From: Jonathan Perks [REDACTED]
Sent: 24 September 2019 10:56
To: Oliver McGowan [REDACTED]
Cc: Peter Garrett [REDACTED] Zac Denton <Zac.Denton@arun.gov.uk>
Subject: RE: Project Ref: FG/46/19/PL - Beach Car Park - Pre commencement condition

Arun District Council Project Ref: FG/46/19/PL

Following our telephone conversation last week regarding the proposed grid force system and your planning consultation comments, please find attached product details and revised parking layout for your information.

01 PROPOSED SITE PLAN
Scale: 1:200

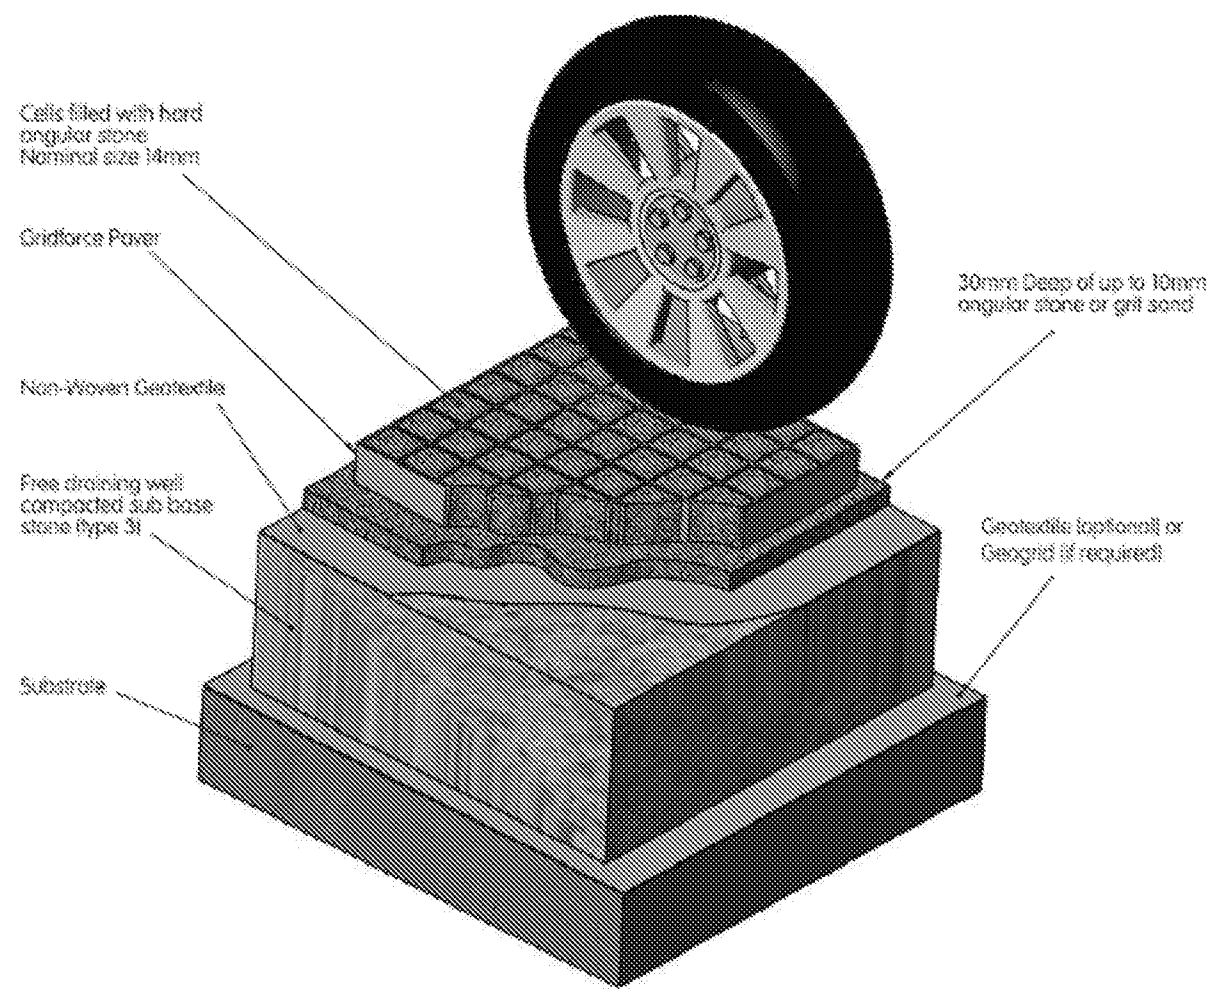
As discussed, we have altered their parking layout so that it does not conflict with the PROW and we have now allocated dedicated clear zones to ensure no cars obstruct the PROW across the car park. We can also include signage adjacent to the footpath entrances reminding drivers not to obstruct the footpath access points.

To recap our conversation regarding the proposed grid force system, the cafe have confirmed they will include the car park areas covered by their grid force system within their management plan. The cafe will ensure levels of infill gravel are maintained regularly especially across PROW route.

The grid force system is fully Part M compliant and also includes small raised studs on top of the plastic grid to help reduce slip risk. Please see the attached information for further clarification. Please see first page on the GF40 pdf, it shows the nonslip spikes on top of the paver cells. We are also using 4/10mm hard angular gravel for the infill of the permeable paver cells as shown in the brochure.
